Waterloo Metro Quarter OSD Northern Precinct

Detailed State Significant Development
Application
SSD-79307758

Supplementary Design Report
Response to Submissions

WMQ-BD1-WBG-AR-RPT-002

Sheet title
OVERALL ARRANGEMENT - LEVEL 2

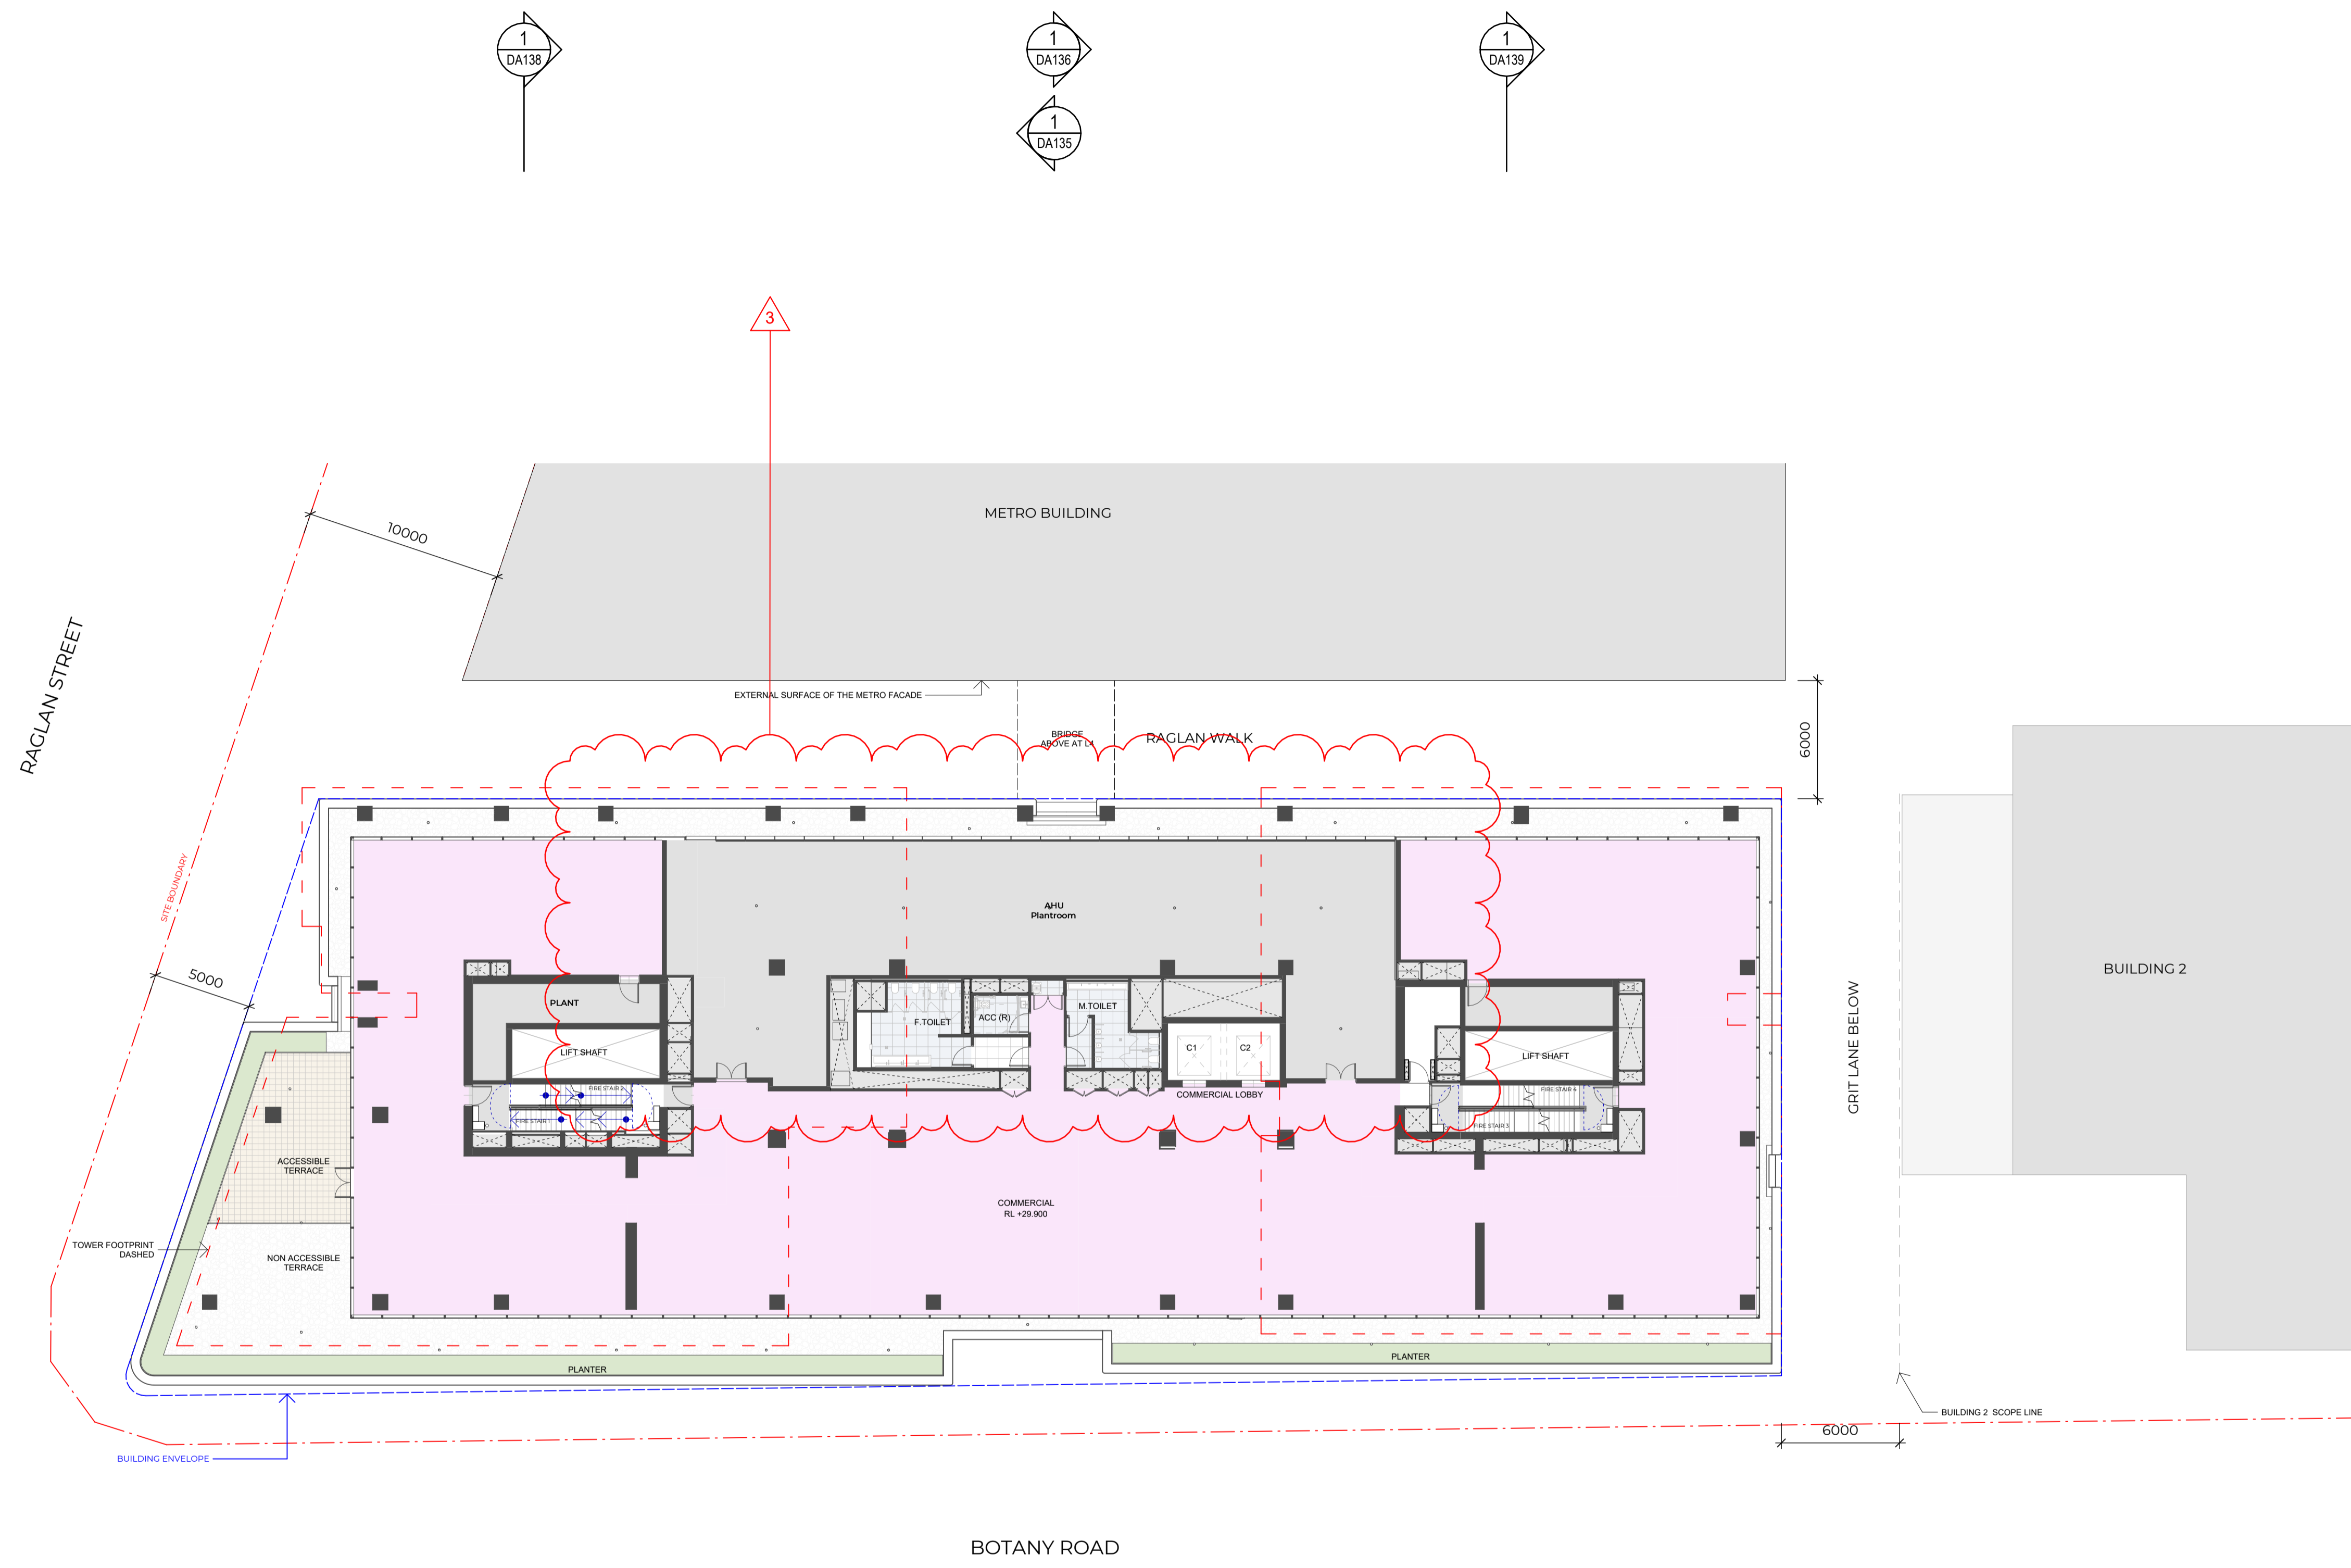
b) Provide a revised Clause 4.6 Statement addressing the objective of Sydney LEP section 6.45(1)(a) in respect to the variation of the minimum non-residential floorspace standard.

The change to the **non-residential** GFA is a result of ongoing design development, which includes the additional plant and riser spaces now required.
